# CITY OF ALBUQUERQUE

November 17, 2021

**Re: McMahon Shopping Center**  
**10550 Unser Blvd NW**  
**Traffic Circulation Layout**  
Architect's Stamp 07-20-2021 (A11-D017)

UNSER & MCMAHON  
ENLARGED SITE PLAN  
ALBUQUERQUE, NM  
PROJECT #2063

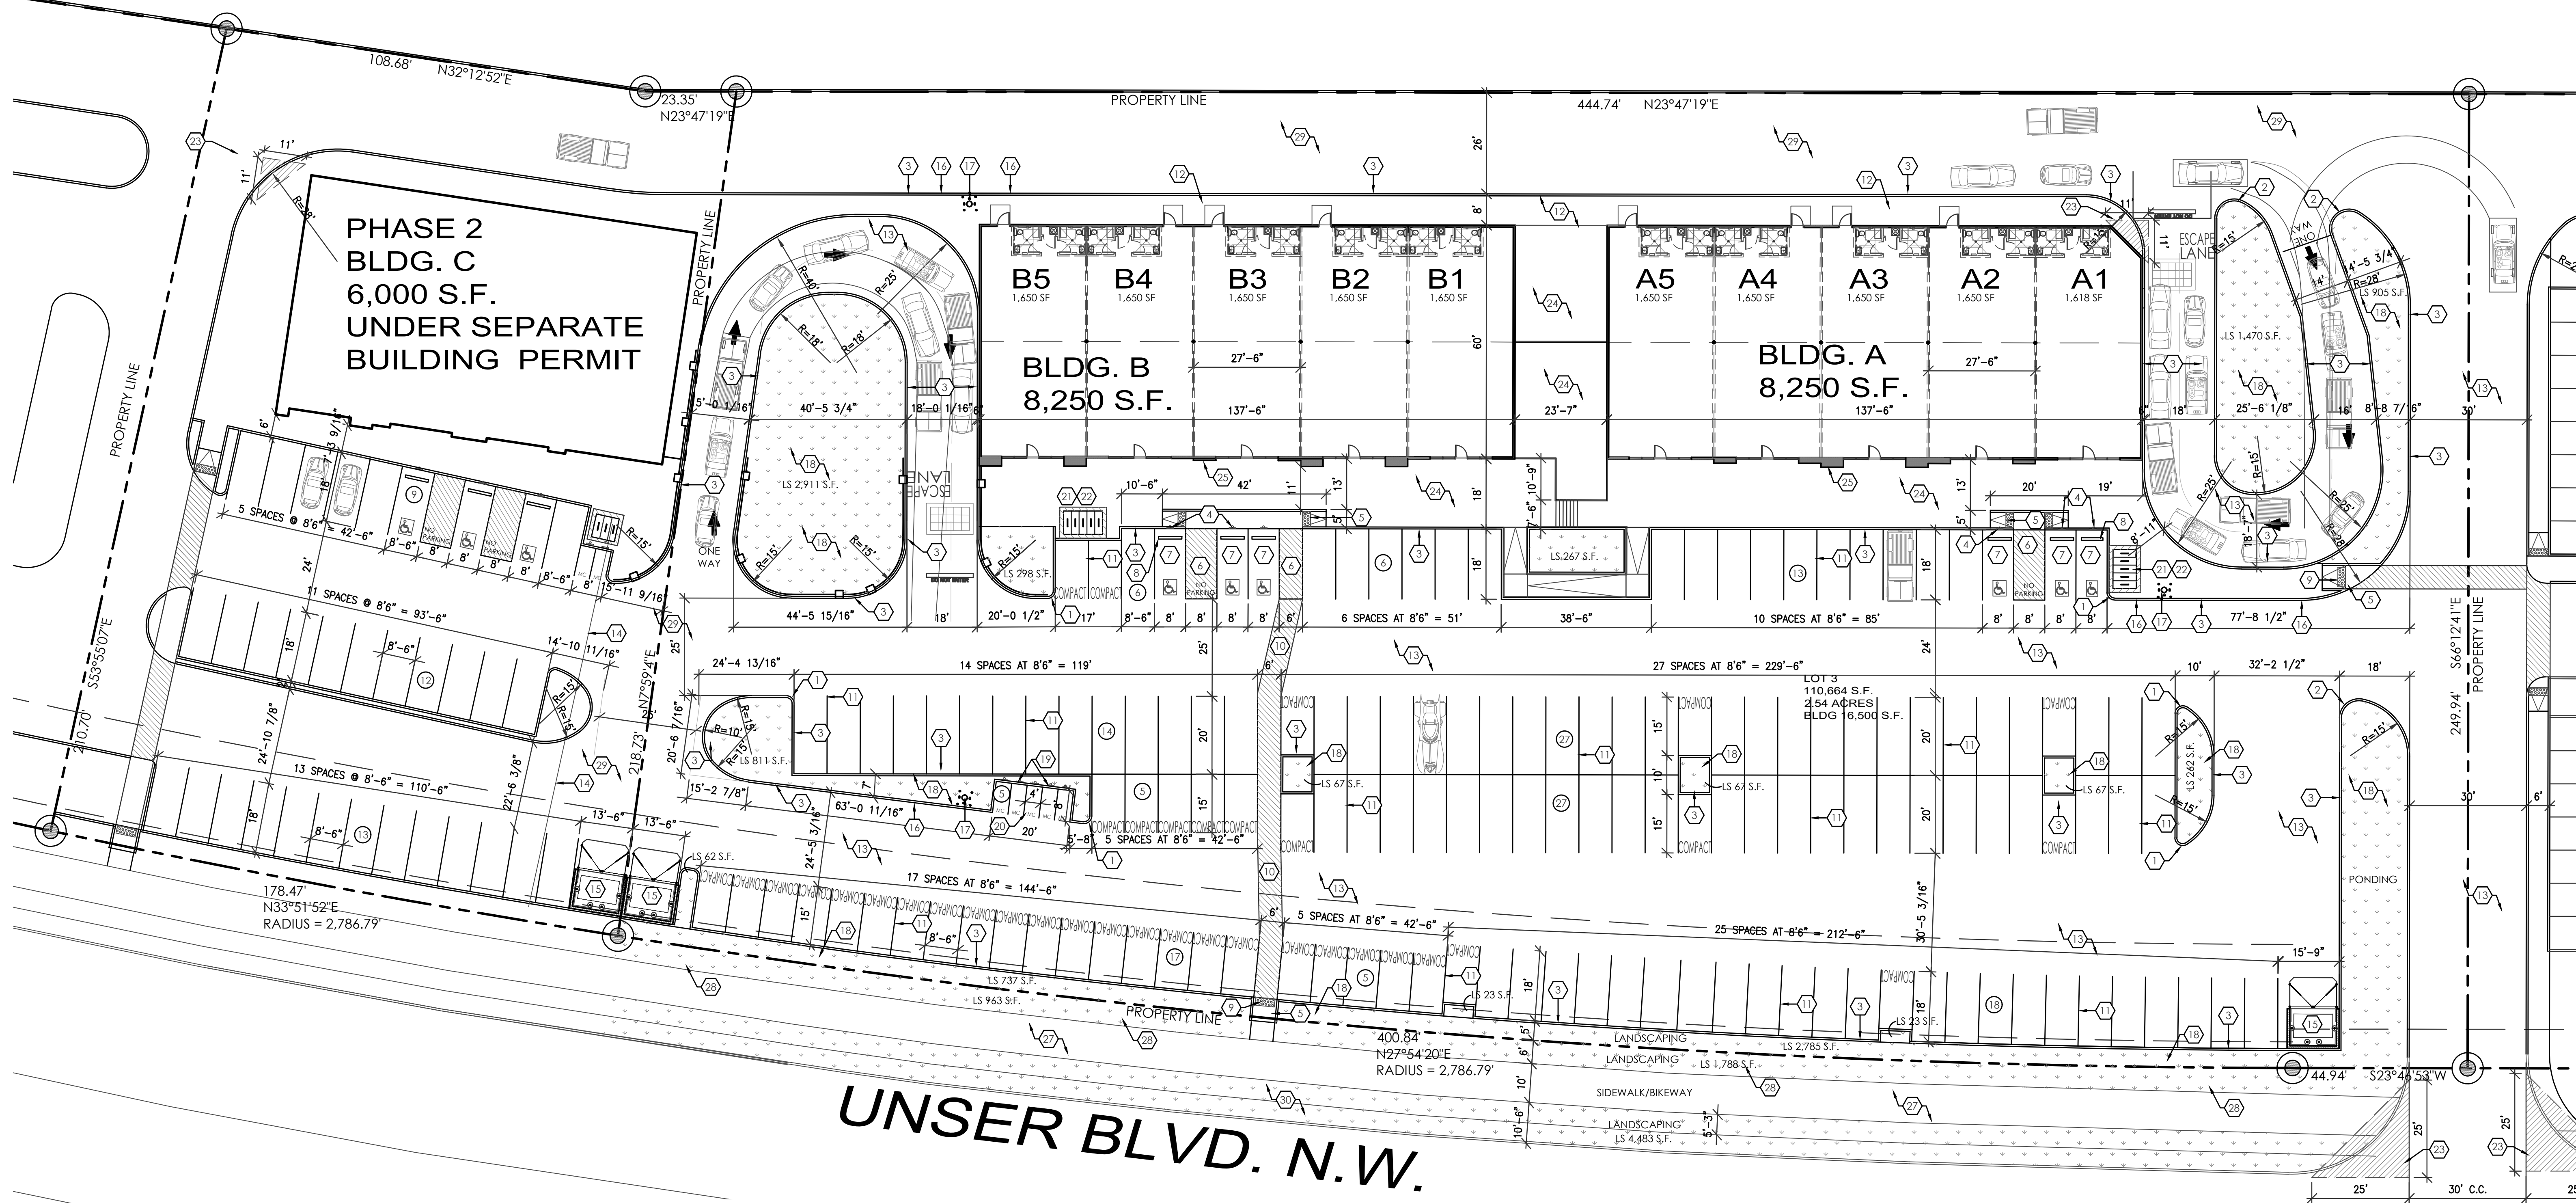
2. Unser Blvd & Entrance:
  - Reference COA std dwg 2426 for entrance design instead of 2425A.
  - Show ADA ramp symbol at both sides of entrance and reference COA std dwg 2445 for detail.

- Northern entrance Segment: Show multi-directional design to service frontage pedestrian path and on site pedestrian. Provide details for this type of ramp design or reference COA std dwg 2445.

3. Keyed Notes (general comments to be modified)
  - All references to CABQ standards need to have drawing number provided and details sheets need to match these drawing numbers, or else just remove standard drawing numbers and use the detail number with sheet number as reference.

- Keyed Note 19 (Motorcycle Parking Sign): Provide sign face detail.
  - Keyed Note 30 & 31: Pavement marking detail will need to be provided.
  - Keyed Note 32 (Do Not Enter): Provide sign face detail.

4. Bldg A & B (proposed drive thru):
  - Details will be needed for sign face, pavements markings and striping at entrance/exit for drive thru lanes.

- All parking stalls will need to be 8'-6" in width instead of 8'.
- Bldg B: The third ADA access aisle/6 ft pedestrian pathway will need the "NO PARKING" pavement markings shown.
- Bldg A: the 2 proposed ADA parking stalls will need another 6 ft access aisle to service the last ADA stall.
- Bldg A & B: The two proposed ramps in front of Van accessible aisle will need a railing to avoid any type of tripping hazard with grade change.
- Proposed Planter (LS 267 SF) between Bldg A & B: Hand railing (design/follow per **ADA STANDARD for ACCESSIBLE DESIGN**) will need to be provided and details provide for each segment and width shown. The segments will include 5'x5' (2% max.) at each turn with 4 inch plat at bottom of each railing design.

- Ramp location will need to be shown on private propertyAll portions).
- Detail for ramp will need to be provided. Reference COA std dwg 2442.
- Curbing needs to be provided for the ADA 6 ft pedestrian pathway to shield pedestrian between Compact parking stalls.

7. Compact Parking (located behind Unser frontage): You have an offset of drive aisle width realignment.. Explain if this parking stall striping/overlapping onto drive aisle be a traffic safety concern? Provide a solution for this concern.
